Sub plans

This email is regarding the proposed development at 15 Warren Crescent, East Preston. My Team Leader will be unable to review the proposal until the 20<sup>th</sup> of November, if you are able to agree an Extension of Time until this date, it would be appreciated.

1422/P02 B

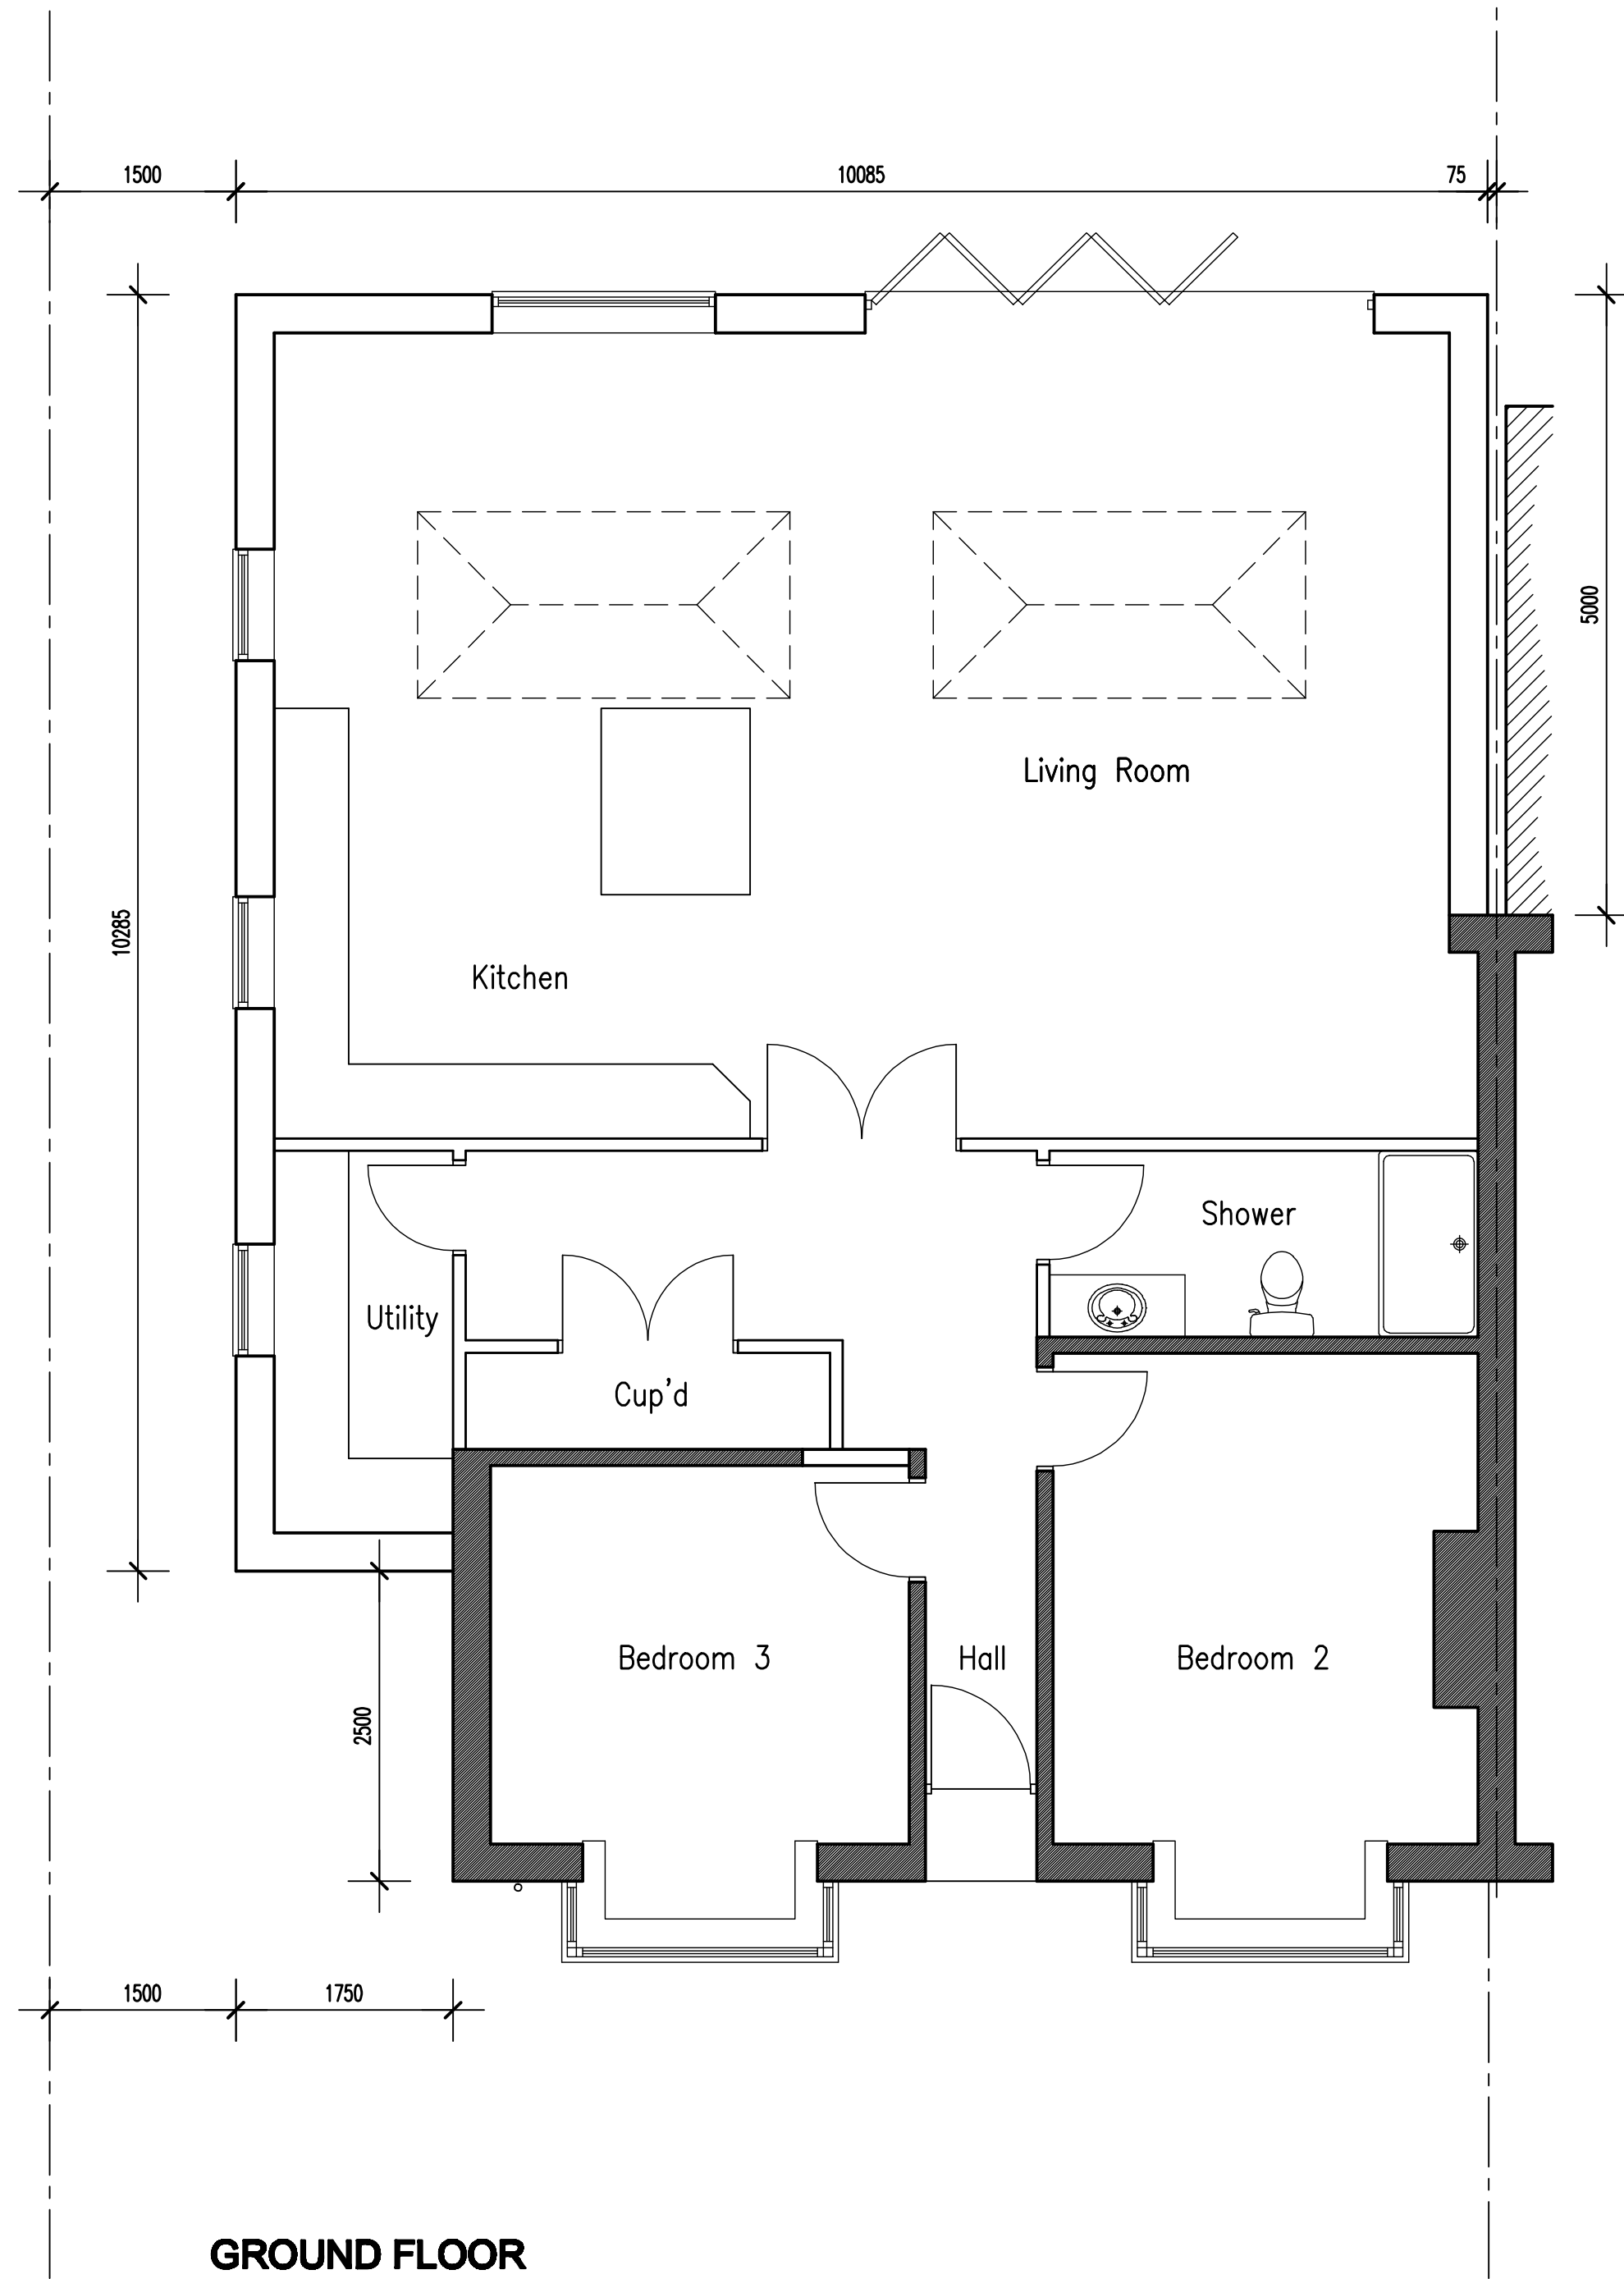
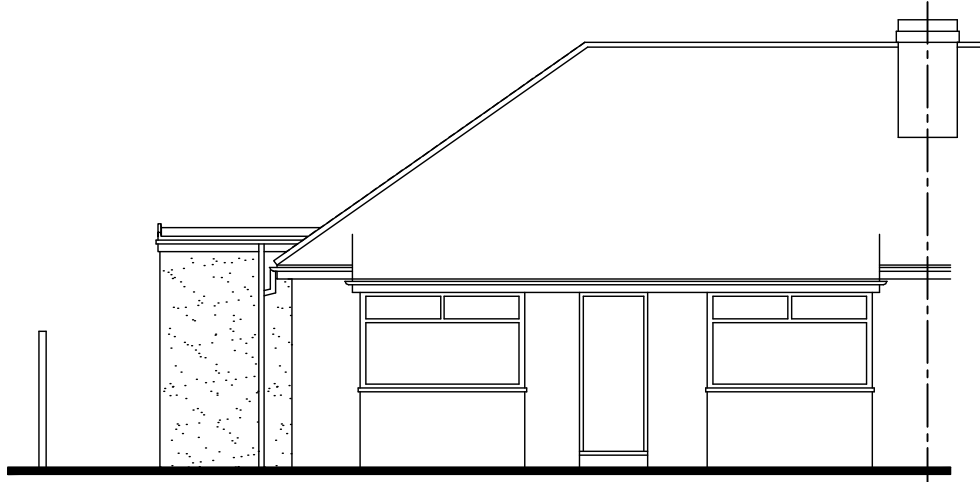
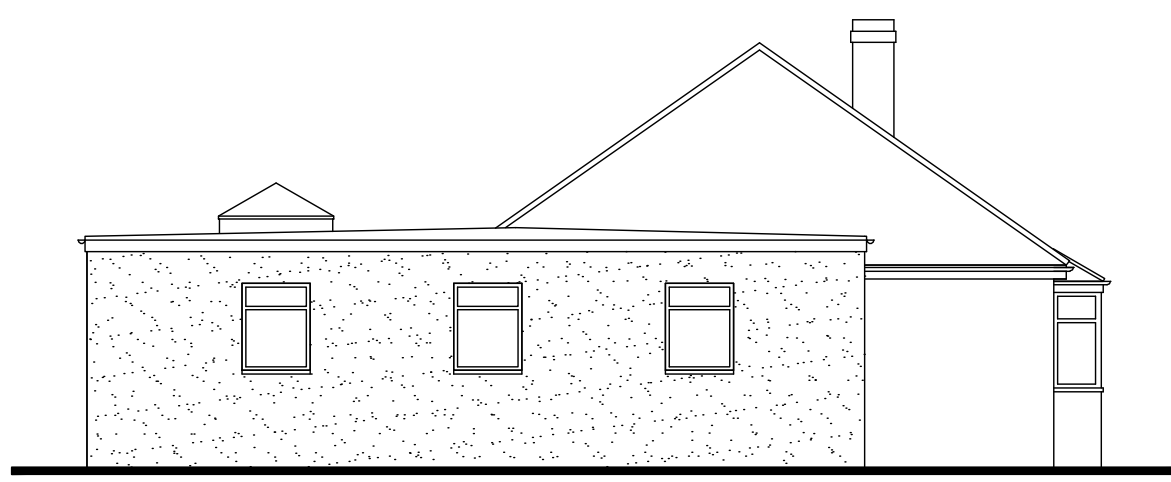
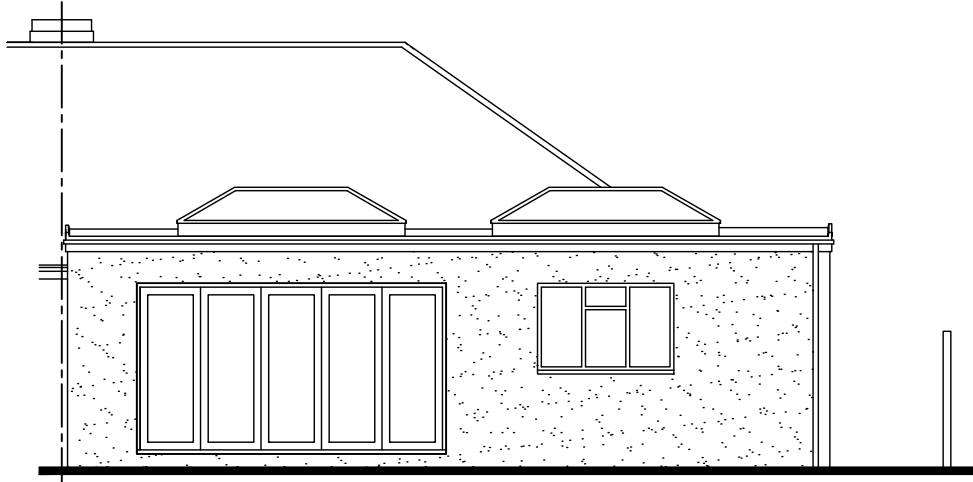
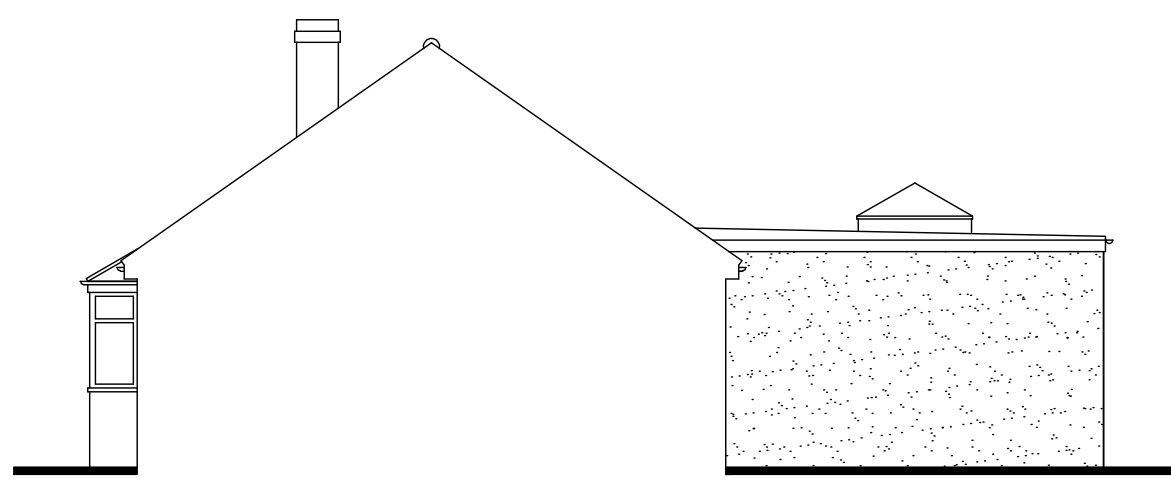
Unfortunately, the 0.5m reduction is not acceptable, if you are able to amend the drawings to be more inline with my previous comments, then this would be appreciated. Alternatively, if you have any other proposals, I am happy to consider these.

However, it is believed that amendments could be made in order to create a scheme that was looked upon more favourably by the LPA. These would be a 1m reduction in length of the rear extension, and a 2.5m reduction of the side element of the extension, away from the street scene.
